UPDATE OF LIST OF PLANNING APPLICATIONS TO BE DECIDED BY

Planning Application 2025/92103

Change of use from dwelling (C3) to a children's home (C2)

17, Far View Crescent, Almondbury, Huddersfield, HD5 8ER

PLAN No. 17FVC-DRA-02 Rev A

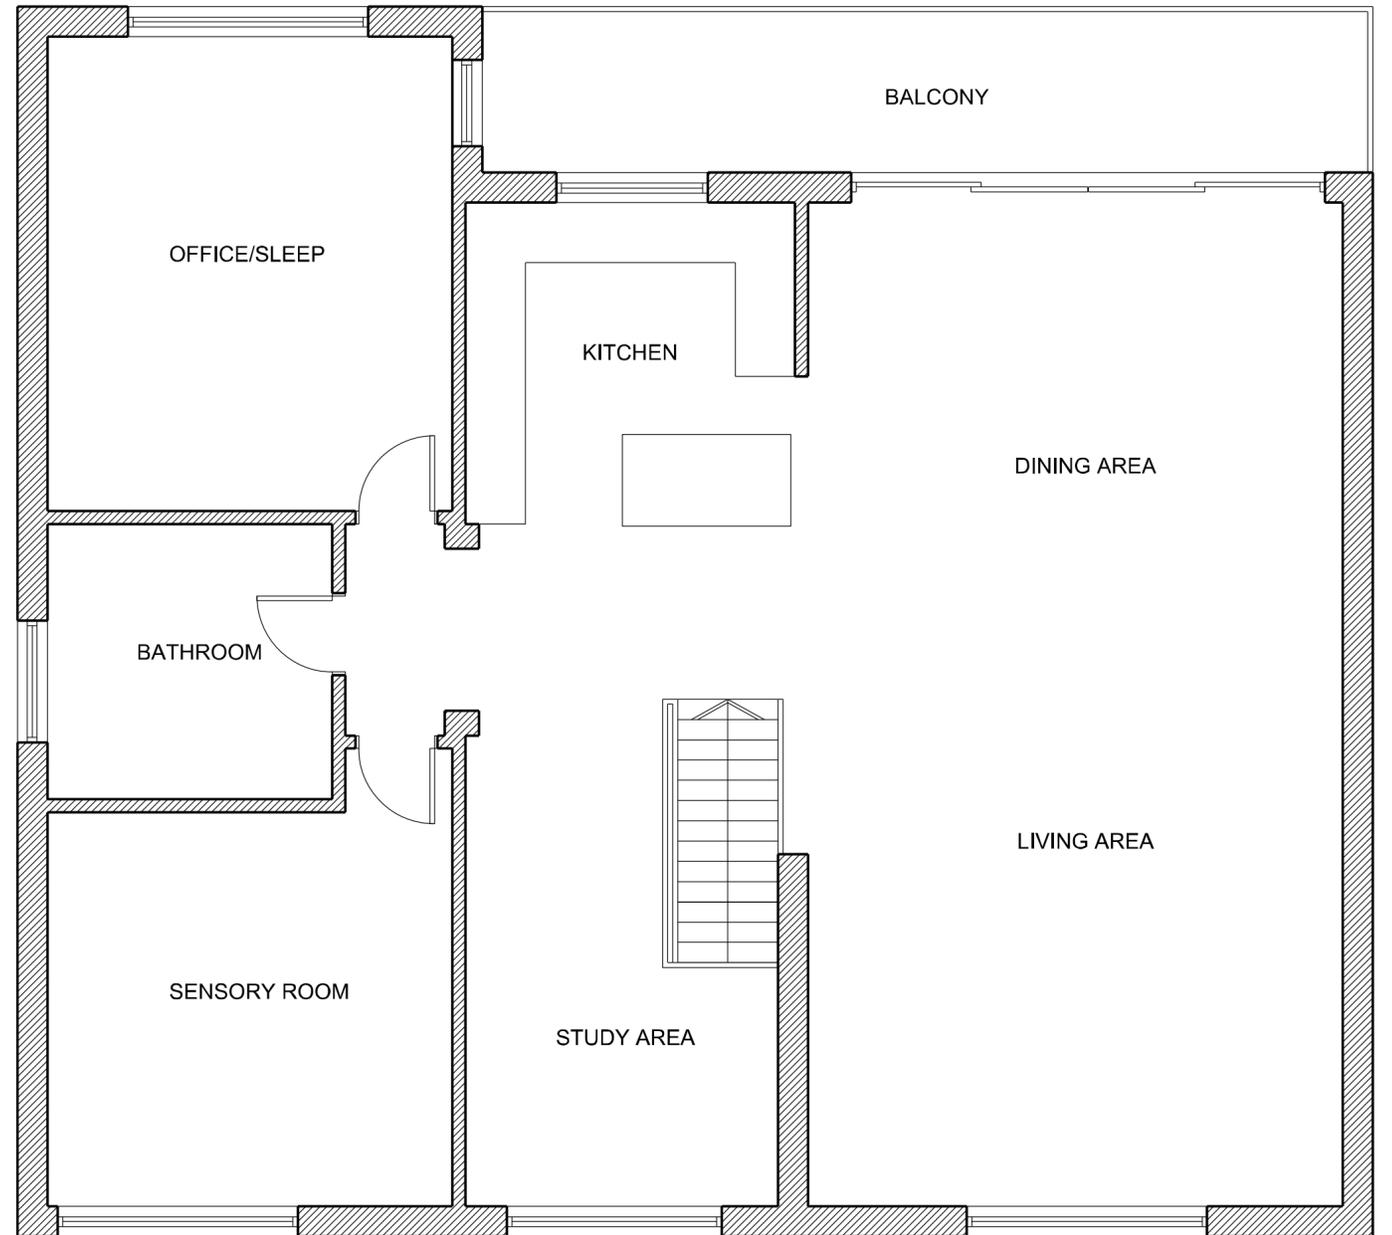
“1. In section 12.0 of the officer's report (Committee Report), it is noted that the applicant has provided an email to the Designing Out Crime Officer stating that the balcony will not be accessible to staff or children. As this is a significant part of the building, I believe it should be made a formal condition of the planning approval to ensure compliance. How will the current residents be assured that this restriction will be enforced, and what mechanisms are in place to monitor its adherence?”

Officer Response: For clarity, this refers to section 10.39 of the Committee Report, not section 12.0. Officers appreciate local resident's concerns regarding the safety of the occupants however, as stated in the Committee

Report, the Designing Out Crime Officer is satisfied with the provided evidence and raised no objections nor suggested additional conditions. It is officers' opinion that to attach a condition of this nature would fail to pass the required test for a planning condition, as detailed in paragraph 57 of the National Planning policy Framework. Furthermore, it is likely that this safety measure would be considered and managed under separate legislation outside the planning system.
